APPLICANT'S RESPONSES TO EXAMINING AUTHORITY'S FIRST WRITTEN QUESTIONS

Drax Bioenergy with Carbon Capture and Storage

Document Reference Number: 8.9

Applicant: Drax Power Limited

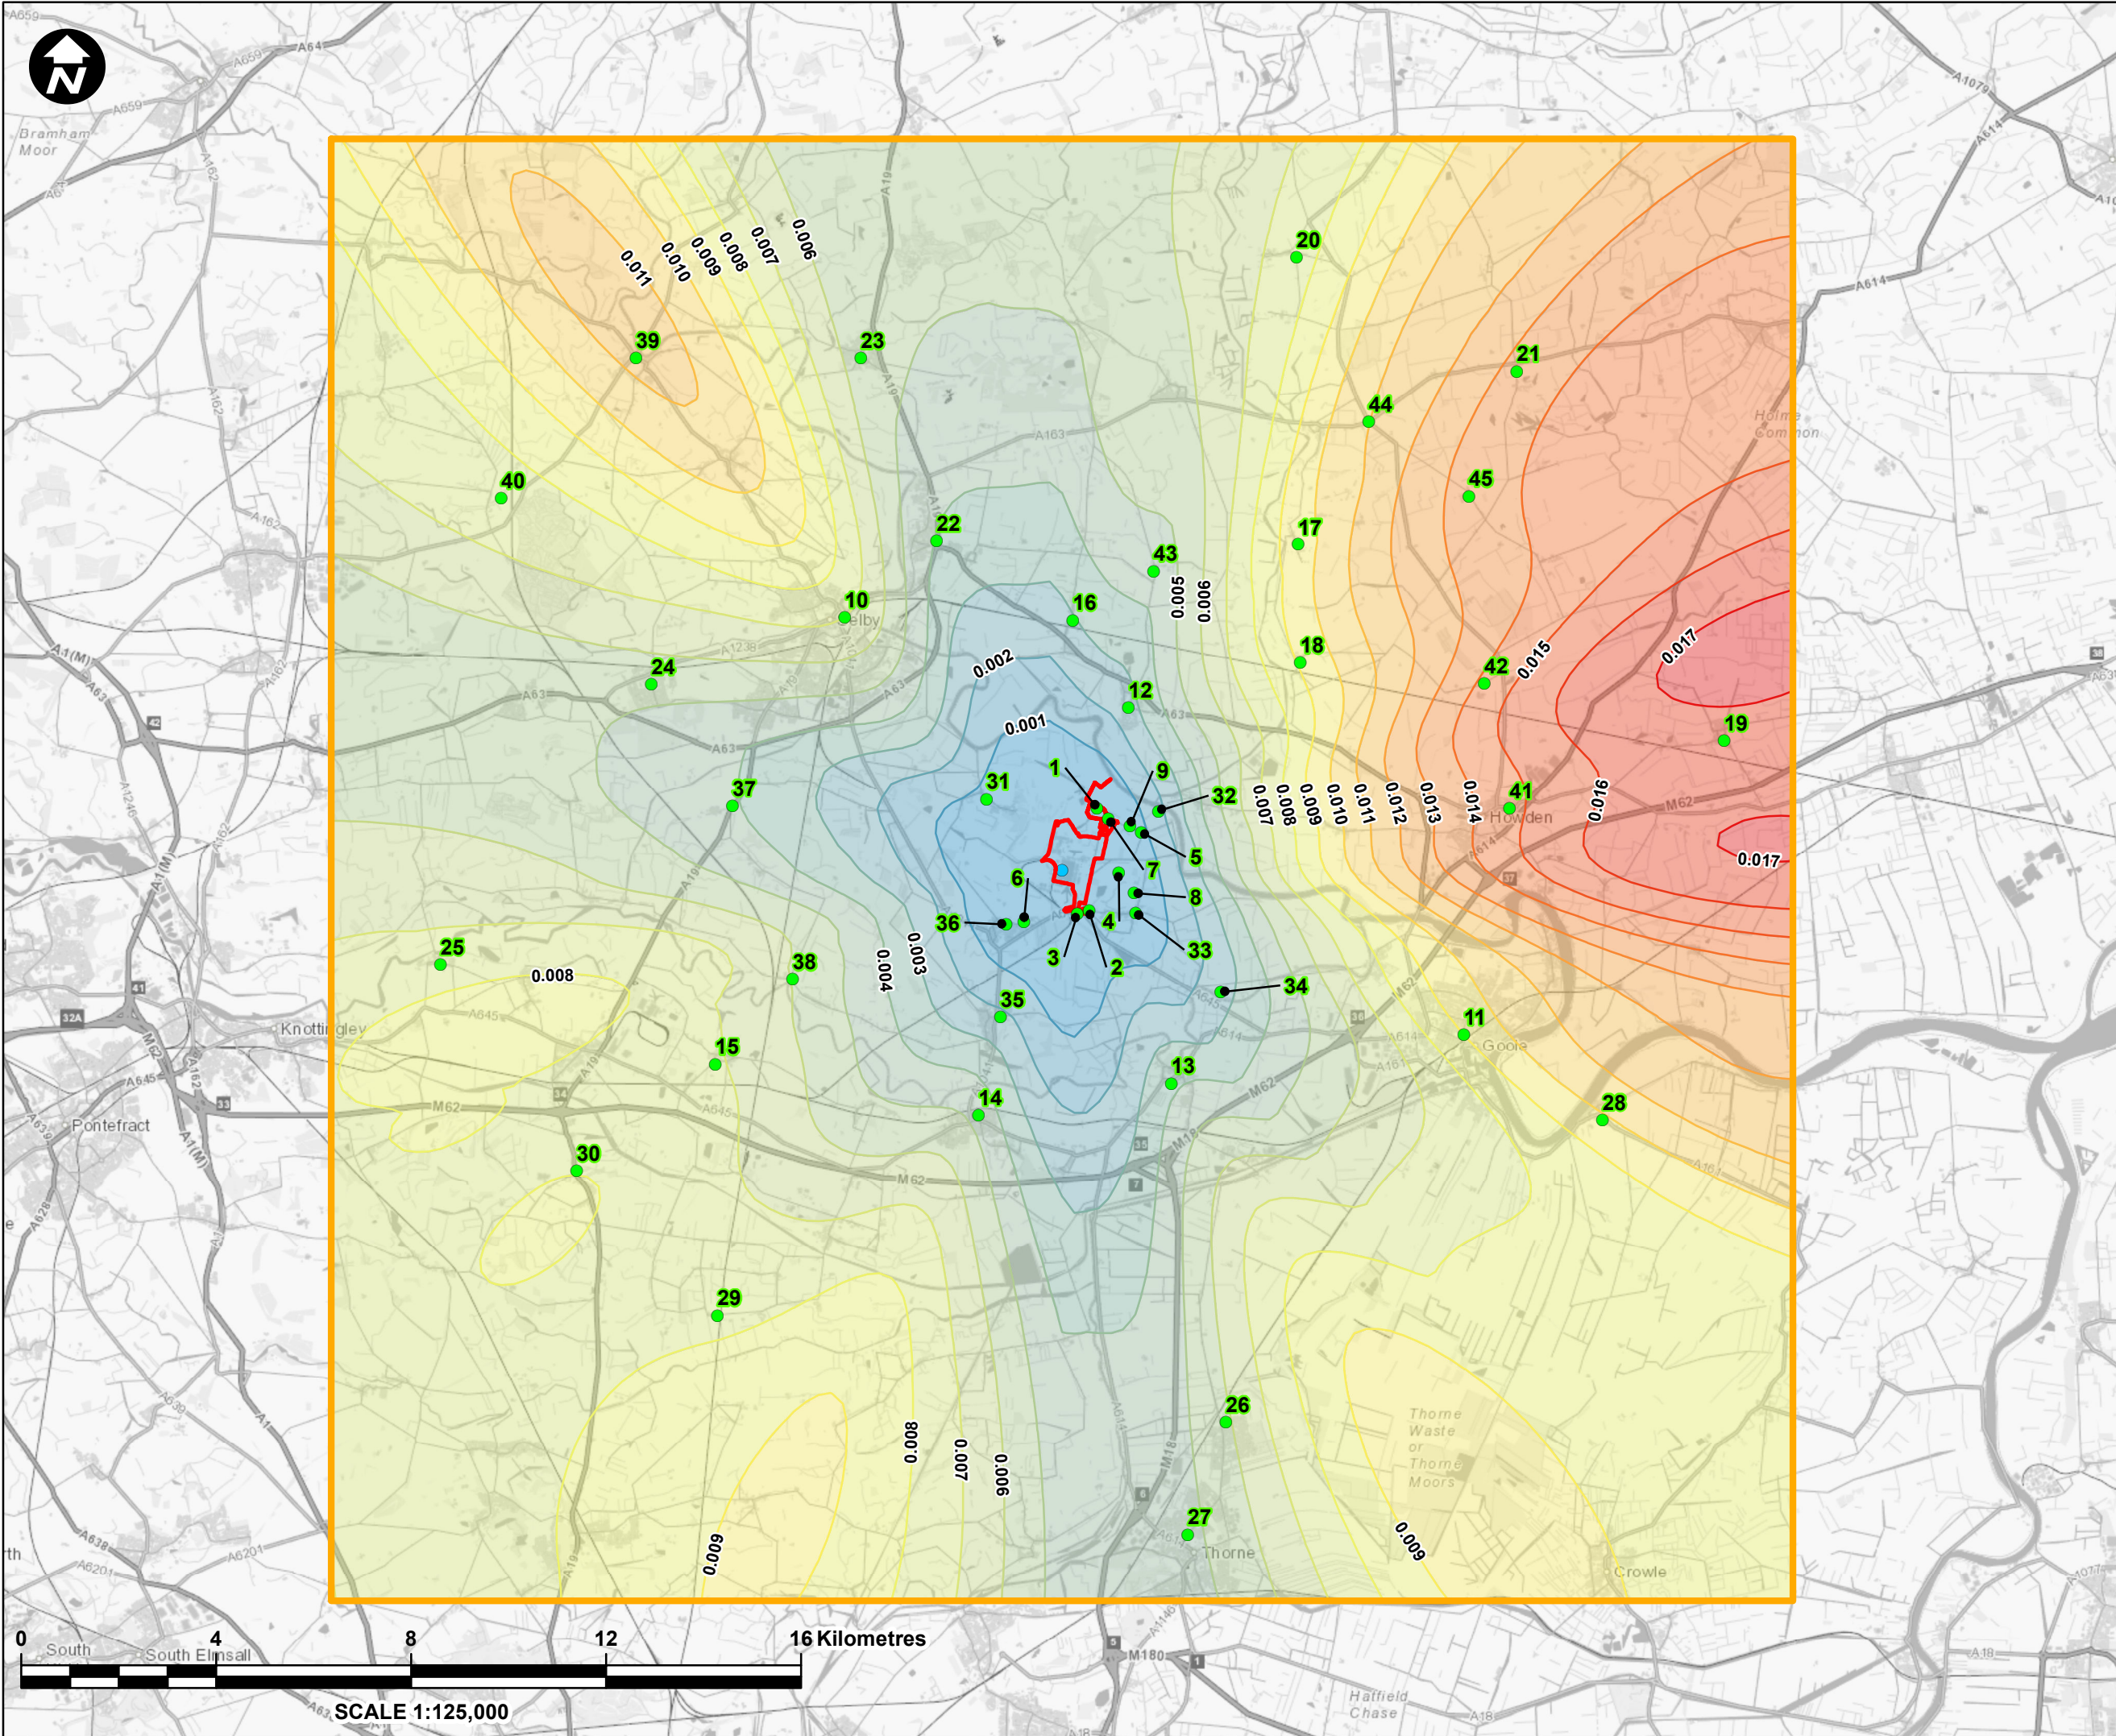
ExA Ref.	Addressed to	Question	Applicant's Response
		and ecological receptors to be fully and accurately assessed?	
AQ.1.4	EA	Figure 6.8 [APP-075] shows a significant area that would fall into the category of slight adverse impact ($\geq 6\%$ of EAL) for annual nitrosamines process contribution, and the dispersion pattern suggests that the area would extend beyond the study area. Does the EA consider the study area to be sufficient for the assessment of the impact of nitrosamines?	<p>The use of a study area that extends 15km from the stack at Drax is well established and consistent with Environment Agency guidance "Air emissions risk assessment for your environmental permit" which can be found at: Air emissions risk assessment for your environmental permit - GOV.UK (www.gov.uk).</p> <p>Whilst the maximum impacts for annual mean nitrosamines occur at the edge of the study area, additional dispersion processes come into play beyond 10-15km from the stack that will reduce the modelled concentrations, primarily related to variations in meteorological conditions over space and time. Moreover, photolytic degradation of the nitrosamines has not been taken into account in the amine chemistry modelling, which will lead to overestimation of pollutant concentrations at distance from the stack.</p> <p>Together these effects would act to reduce concentrations beyond the study area and, it is therefore concluded that study area is sufficient to capture the maximum likely impacts of the Proposed Scheme</p>
